Project name	A38 Derby Junctions Improvement
File reference	TR010022
Status	Draft
Author	The Planning Inspectorate
Date	12 February 2019
Meeting with	Highways England
Venue	Teleconference
Meeting objectives	Draft Documents Feedback Meeting
Circulation	All attendees

A38: Comments on draft documents, February 2019

INSETS
A&B

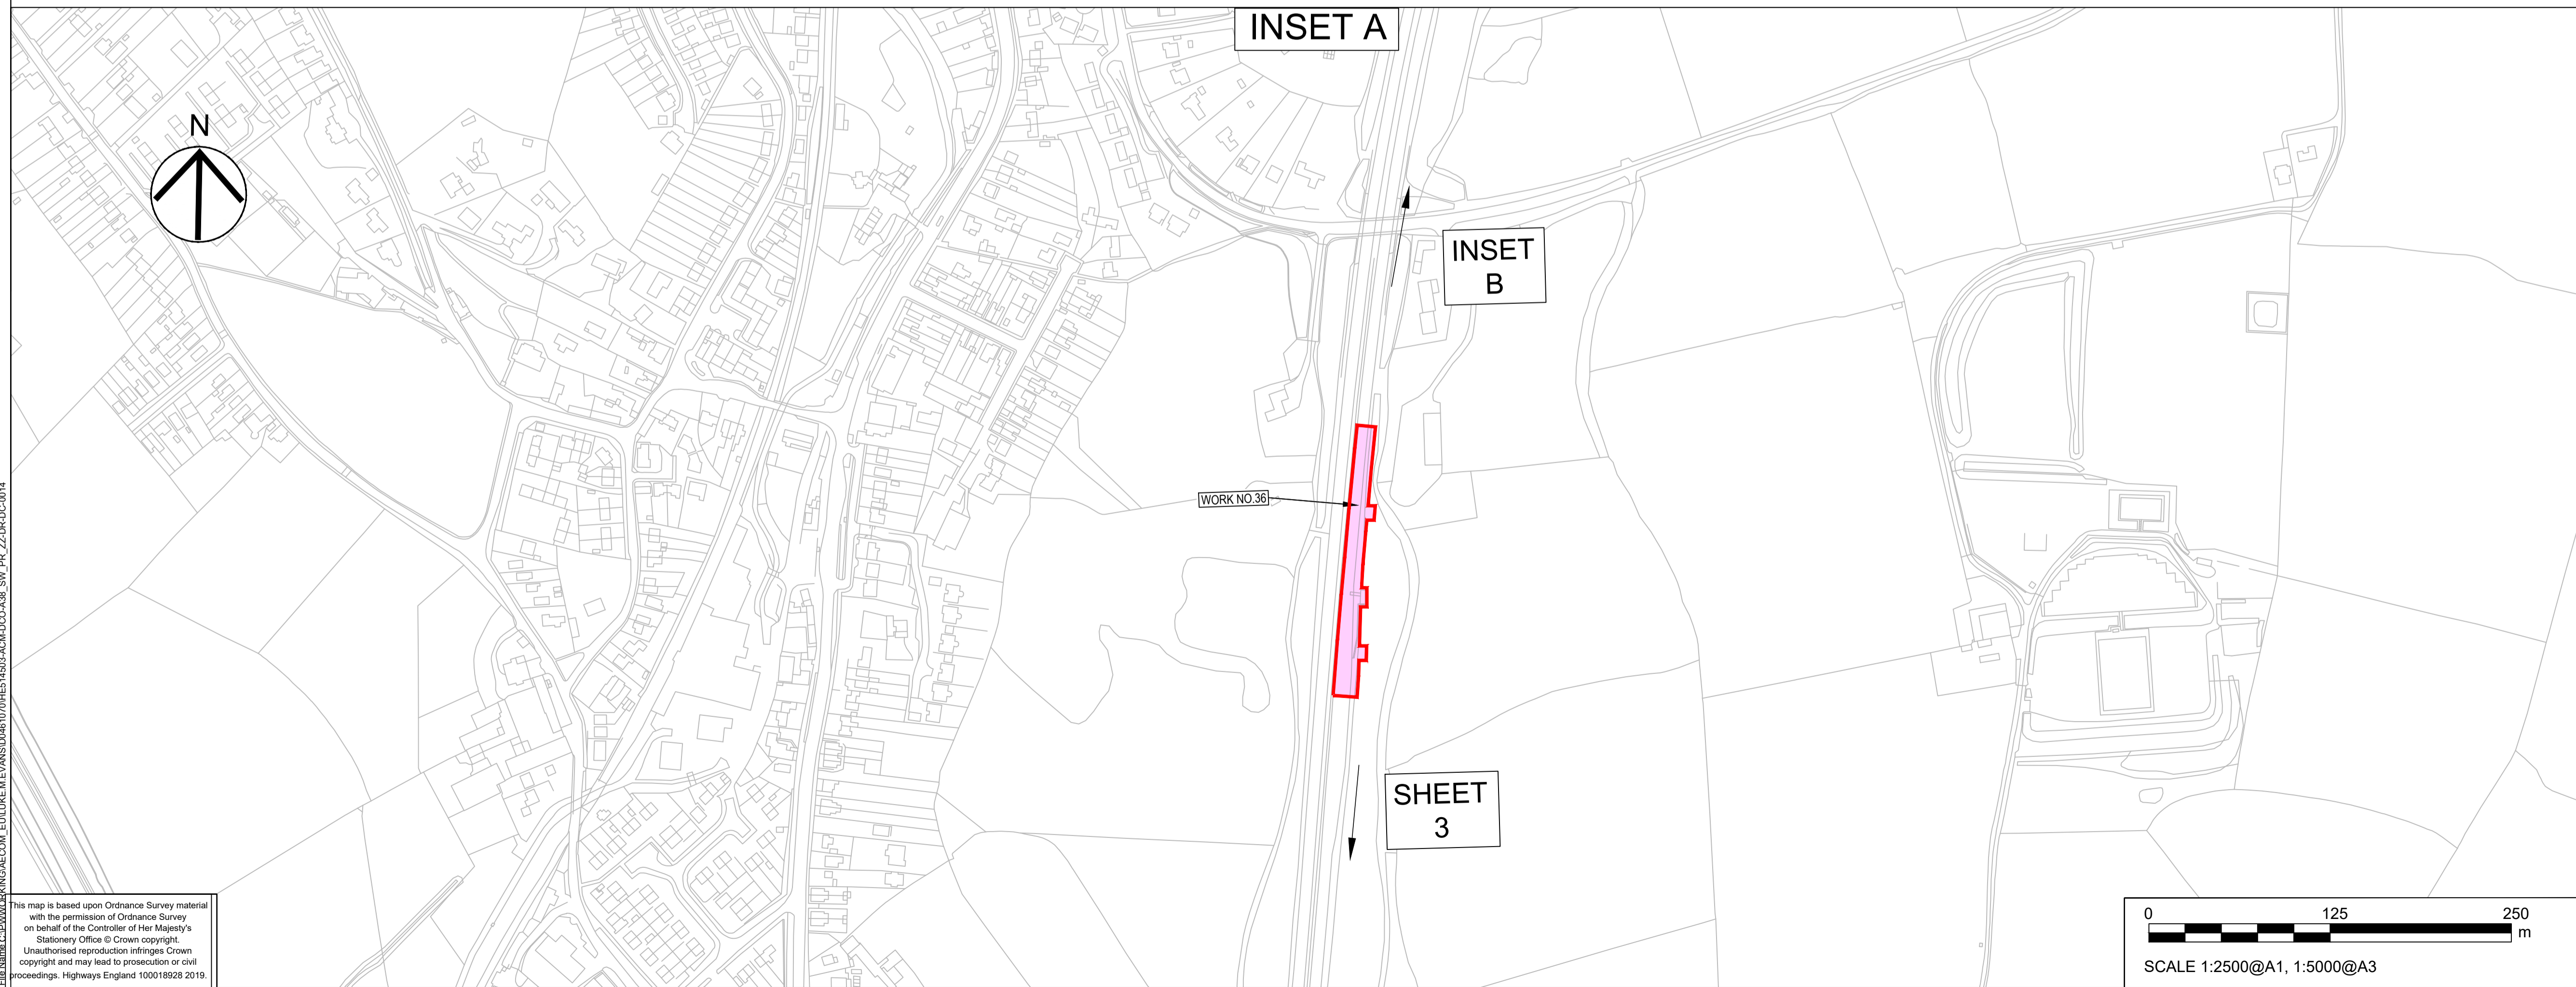
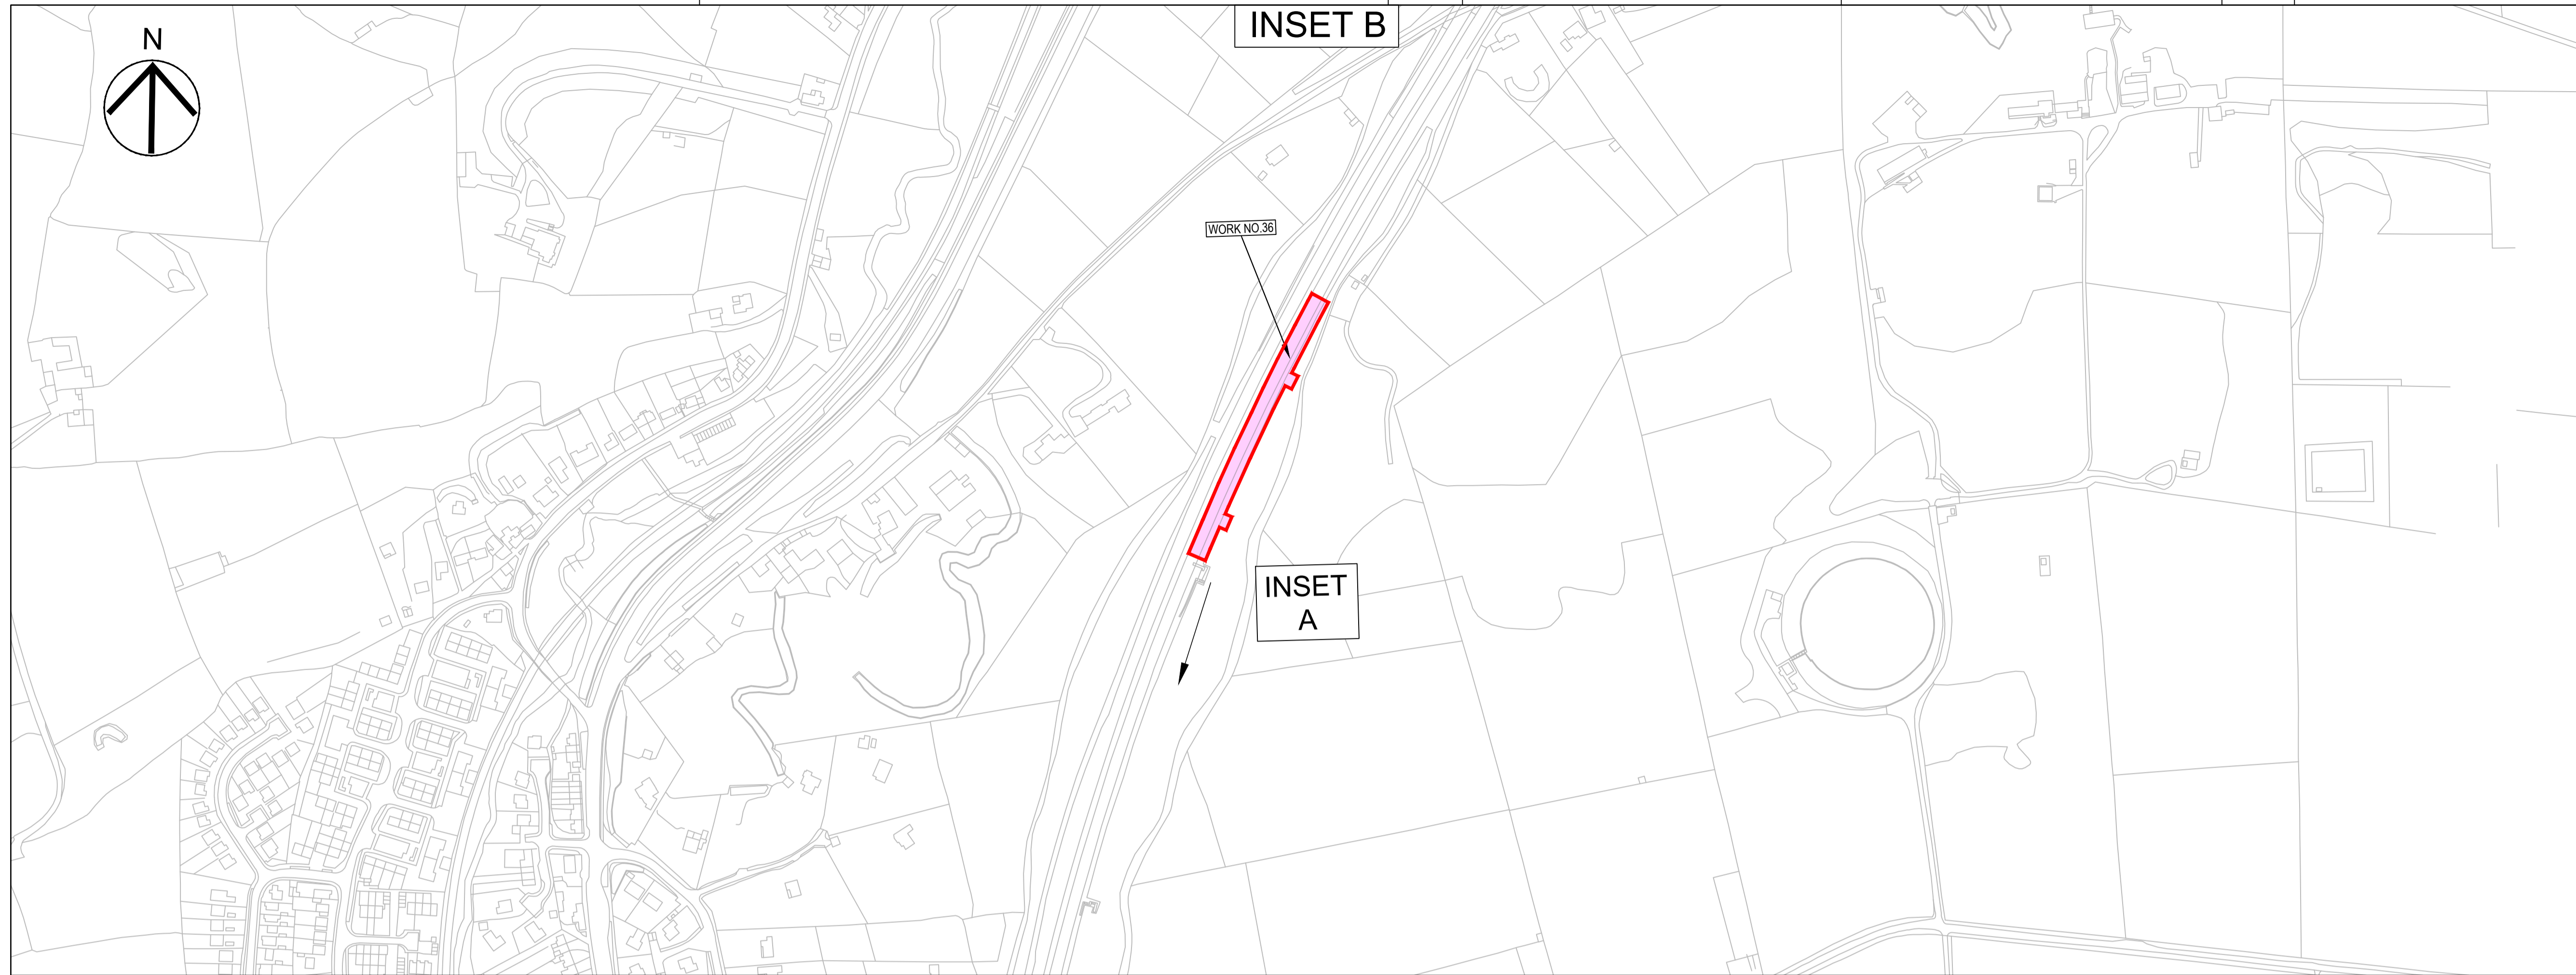
Q No.	Section	Extract from Document	Question/Comment
1	Sheet 2 / Sheet 4 inset A		A cutline or inset box here would assist the legibility of the plans.
2	Sheet 2	<i>e.g. Work 19a shown on Works Plan sheet 2 but DCO states Work 19 not used</i>	There are potential inconsistencies between Works Plans and DCO drafting
3	Sheet 2		There appear to be unshaded unnumbered areas, where no work is proposed, but which lie within the order limits
4	Sheet 3	<i>Work No 31</i>	The limits of deviation of this work are not shown.
5	Sheet 3		Works extend outside the order limits to the north.
6	Sheet 3		Is it clear where Work 33 starts and ends and where Work 29 starts and ends?
